Morecambe Offshore Windfarm: Generation Assets Examination Documents

The Applicant's Response to ExA's Written Questions 3

Document Reference: 9.61

4 Liverpool Bay SPA with 1.5nm CPP1 WTG and OSP Aviation Buffer and 1.5nm Calder WTG and OSP Buffer

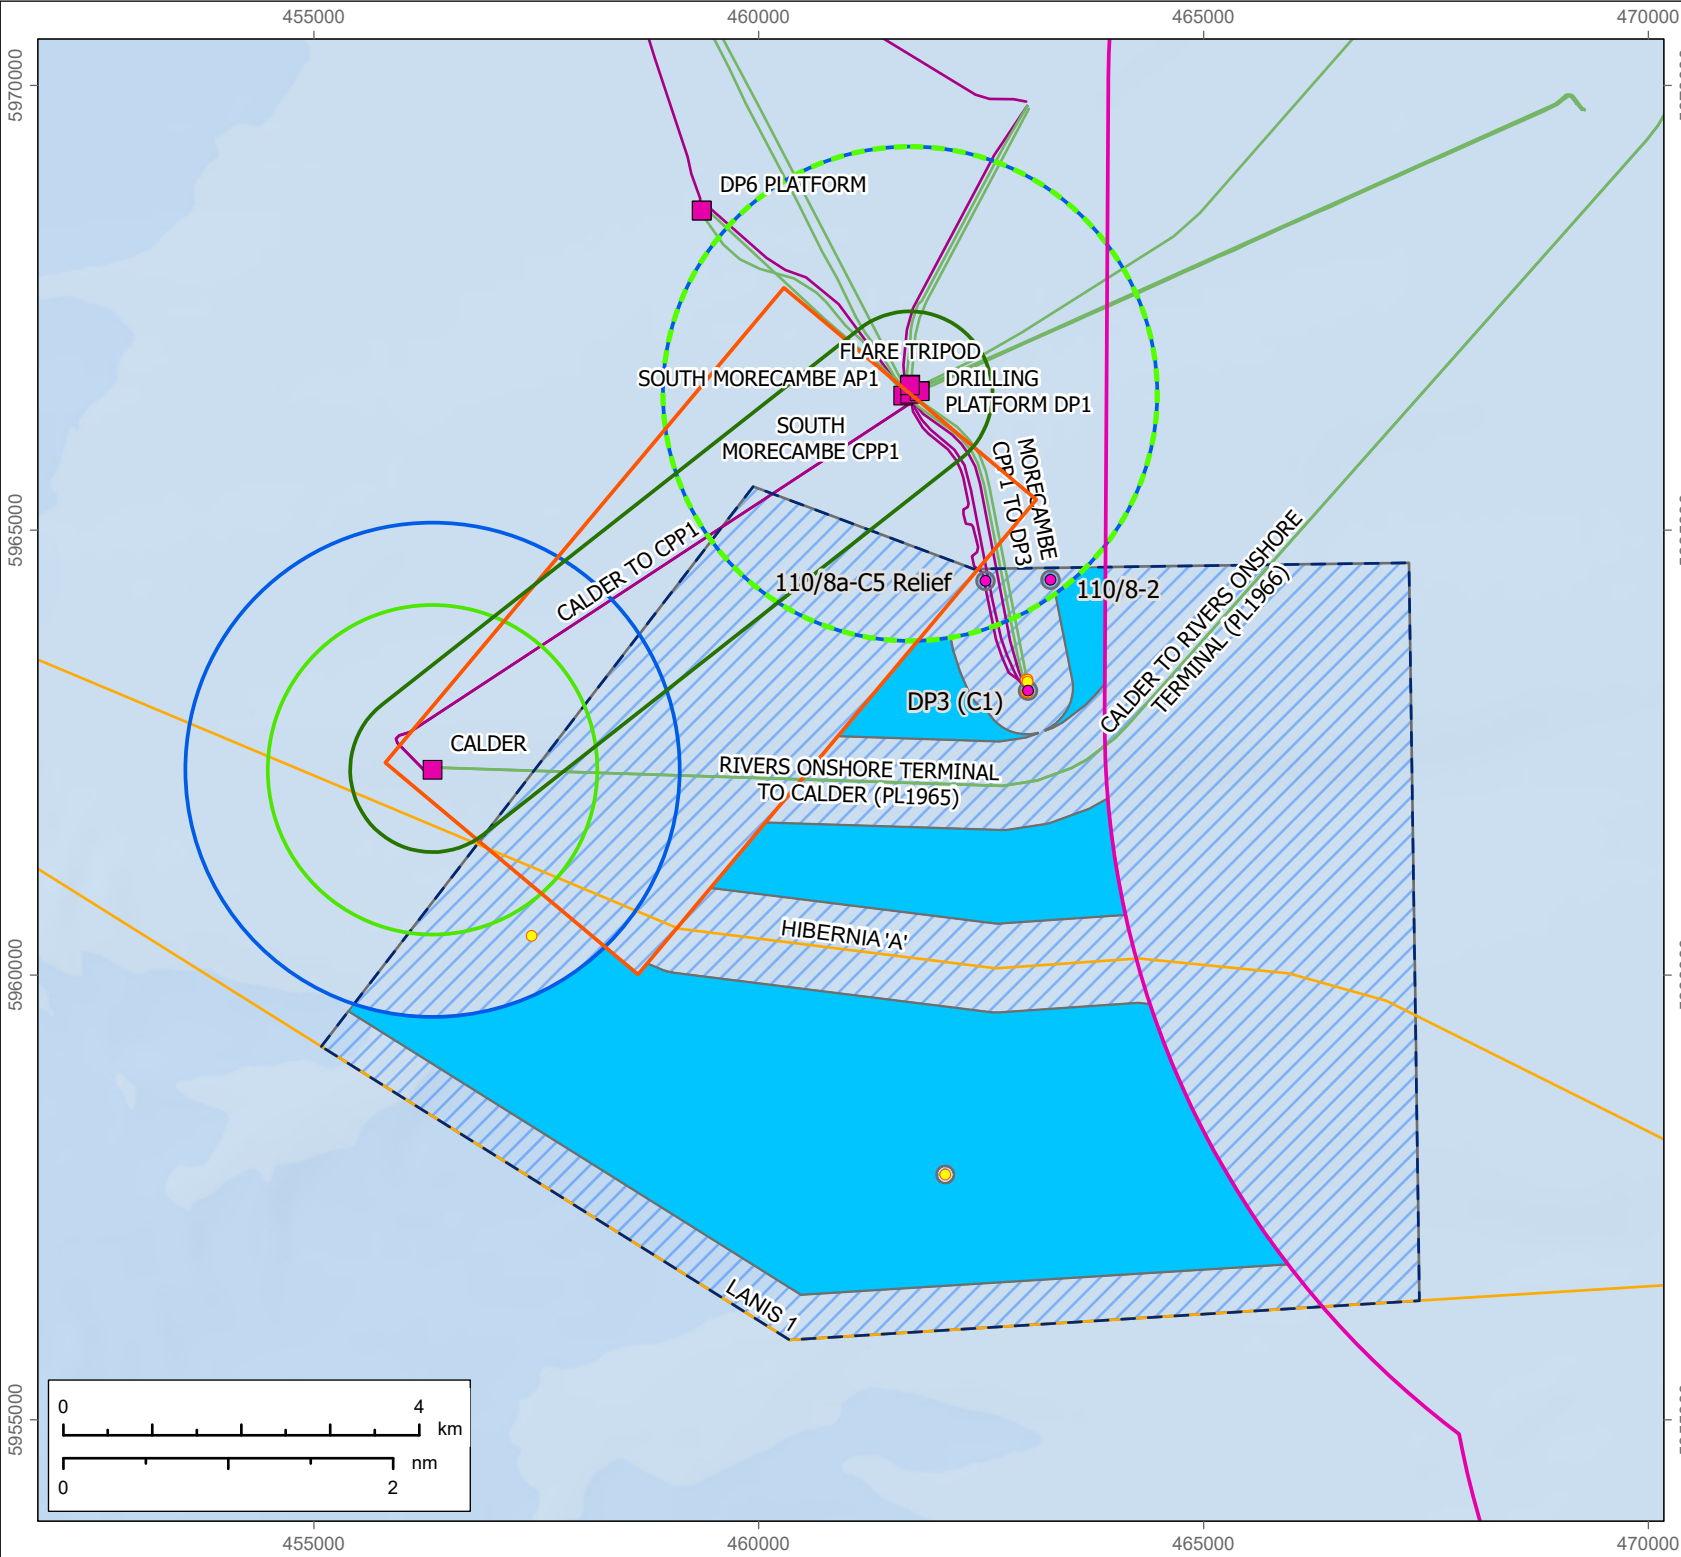
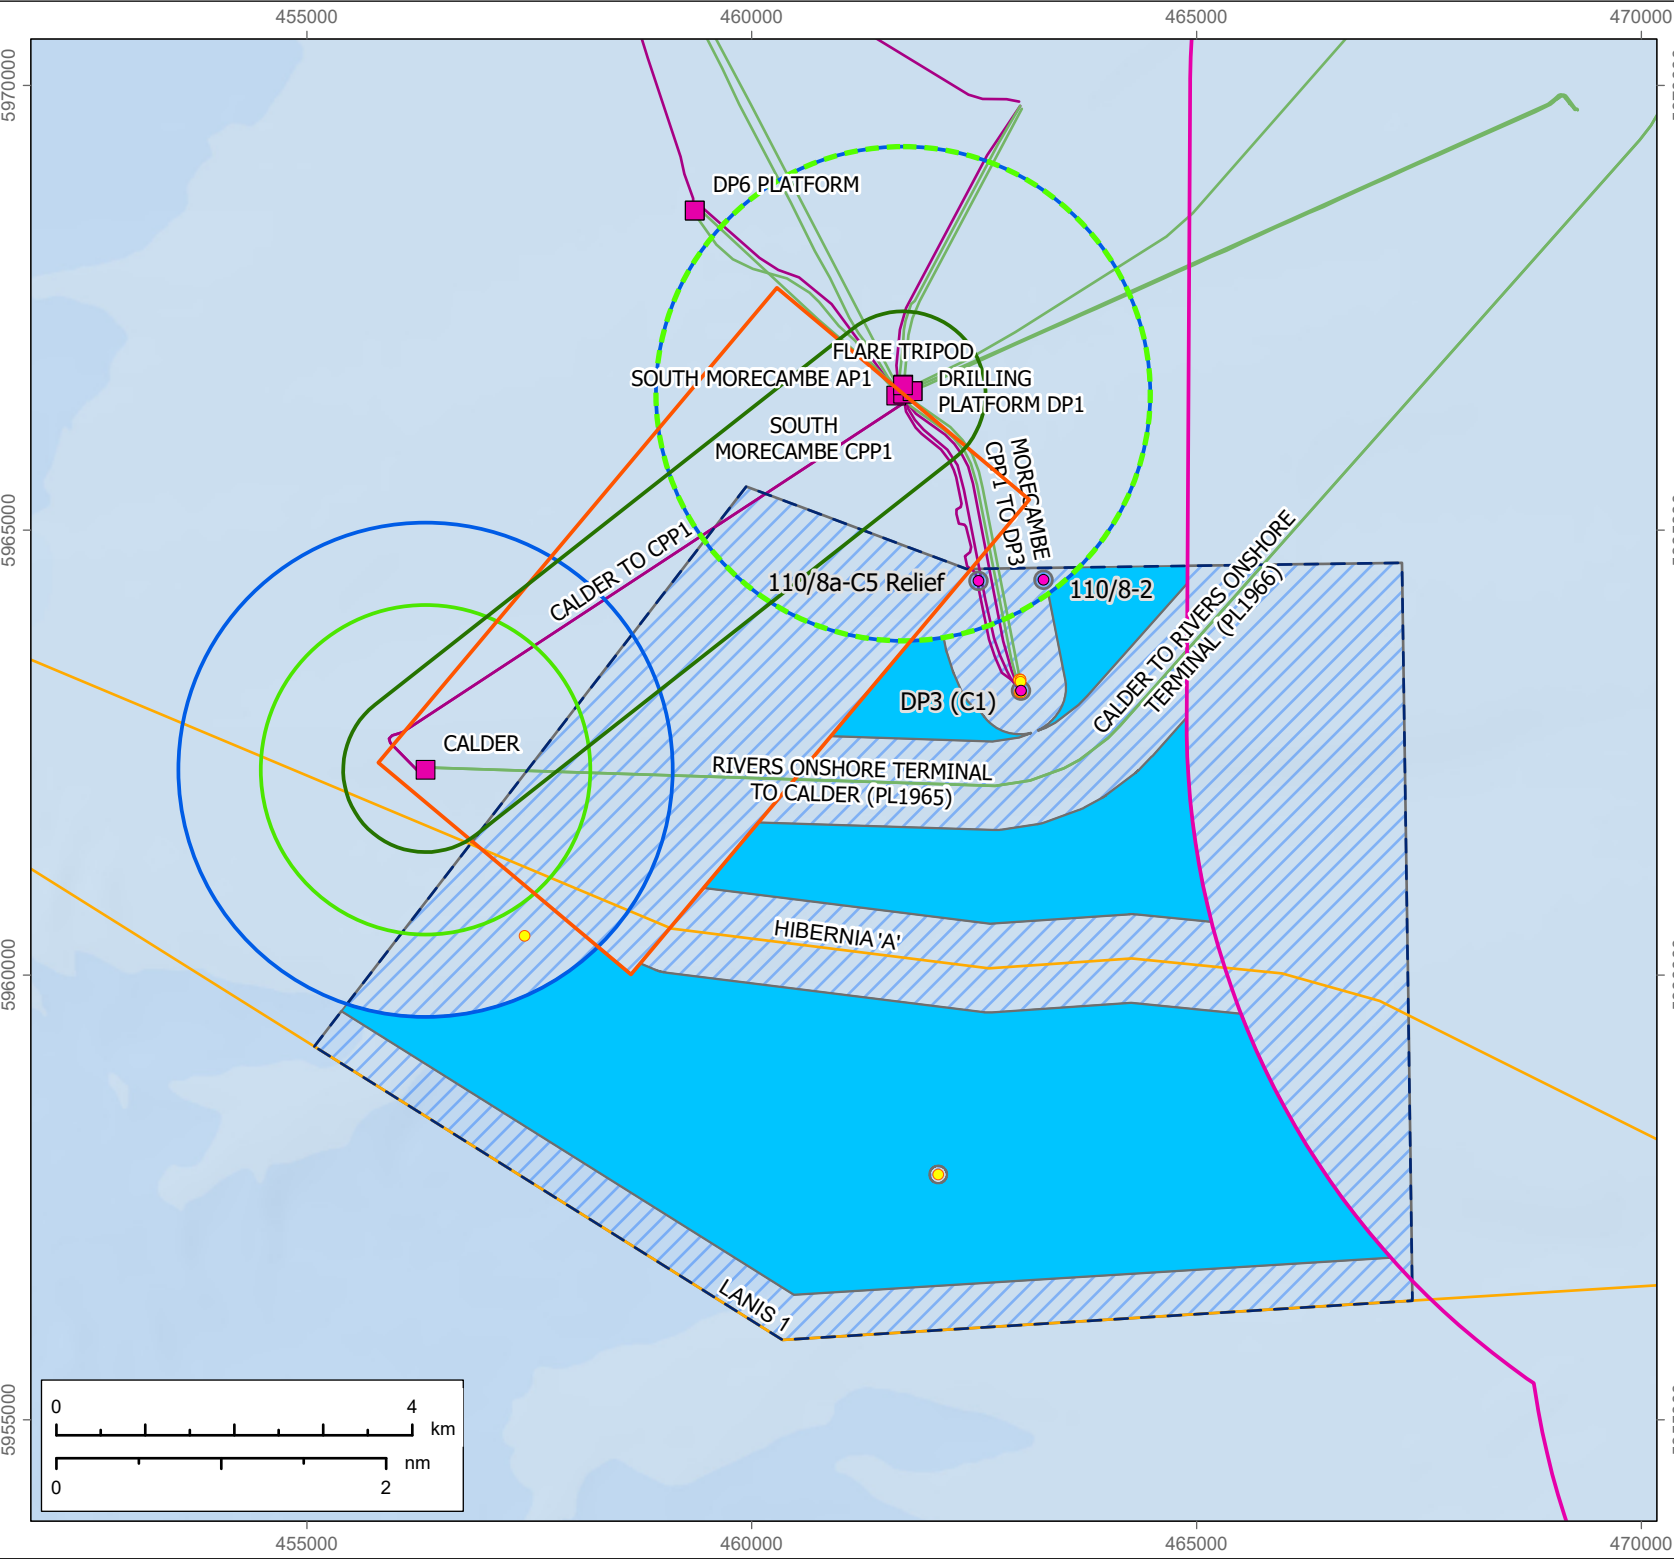
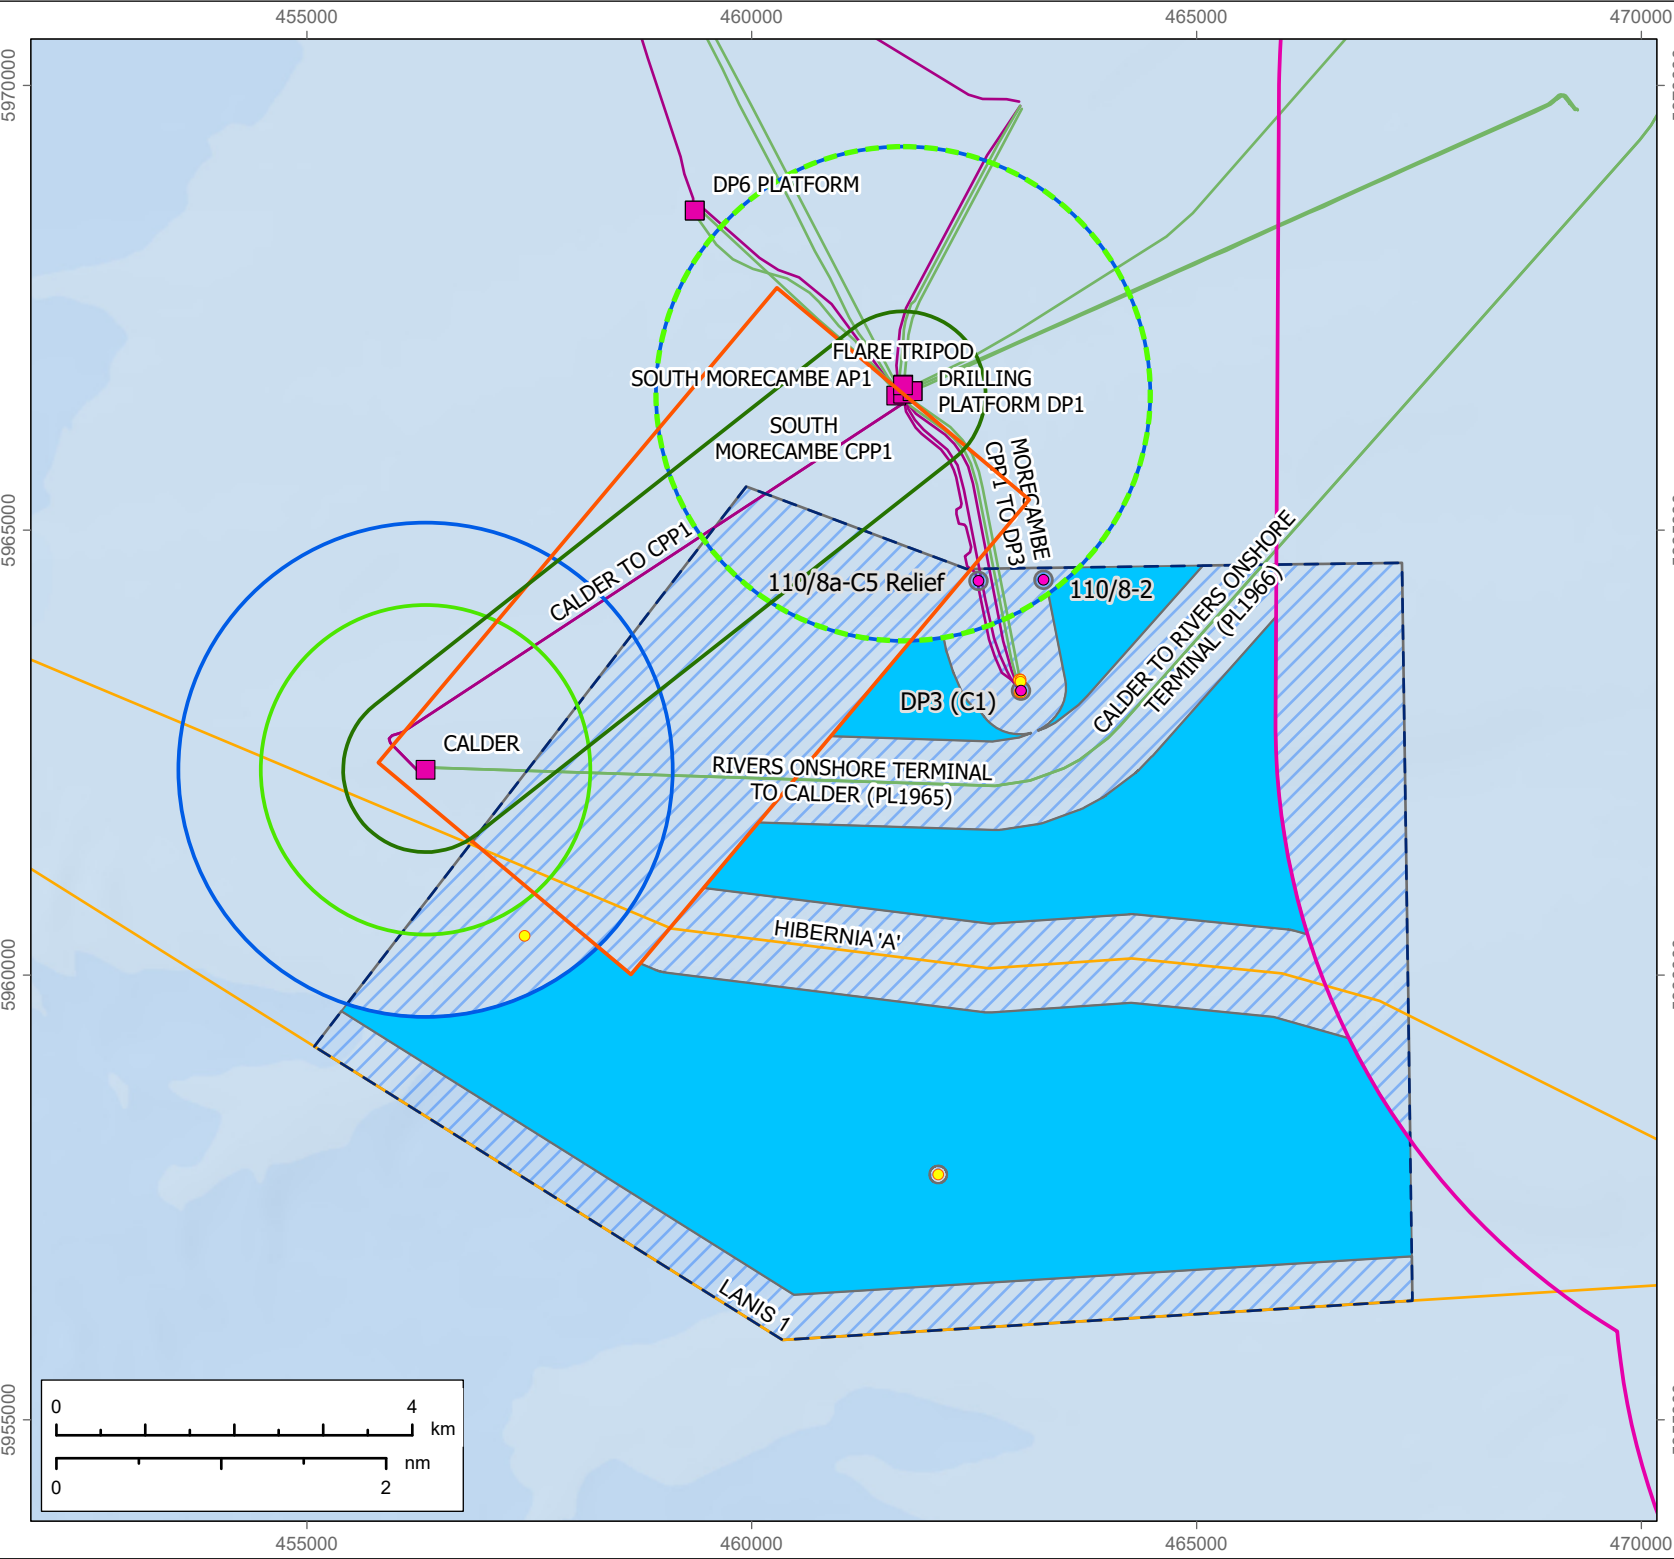
Ref.	Question to:	Question	Applicant's Response										
		<p>b) in Spirit Energy's response to ExQ2CAR5 at D5 [REP5-090] it advises a buffer distance of 1.9nm is the minimum acceptable requirement for safe landing and take-off in daytime VMC and for night VMC this distance would be 2.4nm. In light of this could the applicant provide plans for each alternative SPA buffer scenario in (a) plus each of the increased buffer scenarios from the Calder and CCP1 platforms as set out in the following table.</p>

<p>c) any additional comments or further information the applicant wishes to provide on the implications of each of the above scenarios (noting the applicant's previous response [REP5-070], EXQ2HRA3 and 2HRA6].</p> <p>The ExA is seeking a complete set of alternative scenarios shown on plans, so that, whatever the SoS may determine, if they felt it was appropriate they could include the relevant plan within any final DCO without having to revert to the applicant for that plan. Each should therefore have a different drawing number.</p>	<u>CPP1 WTG and OSP Aviation Buffer</u>	<u>Calder WTG and OSP Buffer</u>	1.9nm	1.9nm	2.4nm	1.9nm	1.9nm	2.4nm	2.4nm	2.4nm	
<u>CPP1 WTG and OSP Aviation Buffer</u>	<u>Calder WTG and OSP Buffer</u>												
1.9nm	1.9nm												
2.4nm	1.9nm												
1.9nm	2.4nm												
2.4nm	2.4nm												
3GEN4	The applicant	<p>Design Statement - Cabling</p> <p>Could the applicant please explain why (former) provision DC15 relating to use of the most direct/ efficient cabling</p>	<p>The Applicant removed the former provision DC15 as it considered that this was duplication of DC10. The Applicant has updated the Design Statement_Rev 04</p>
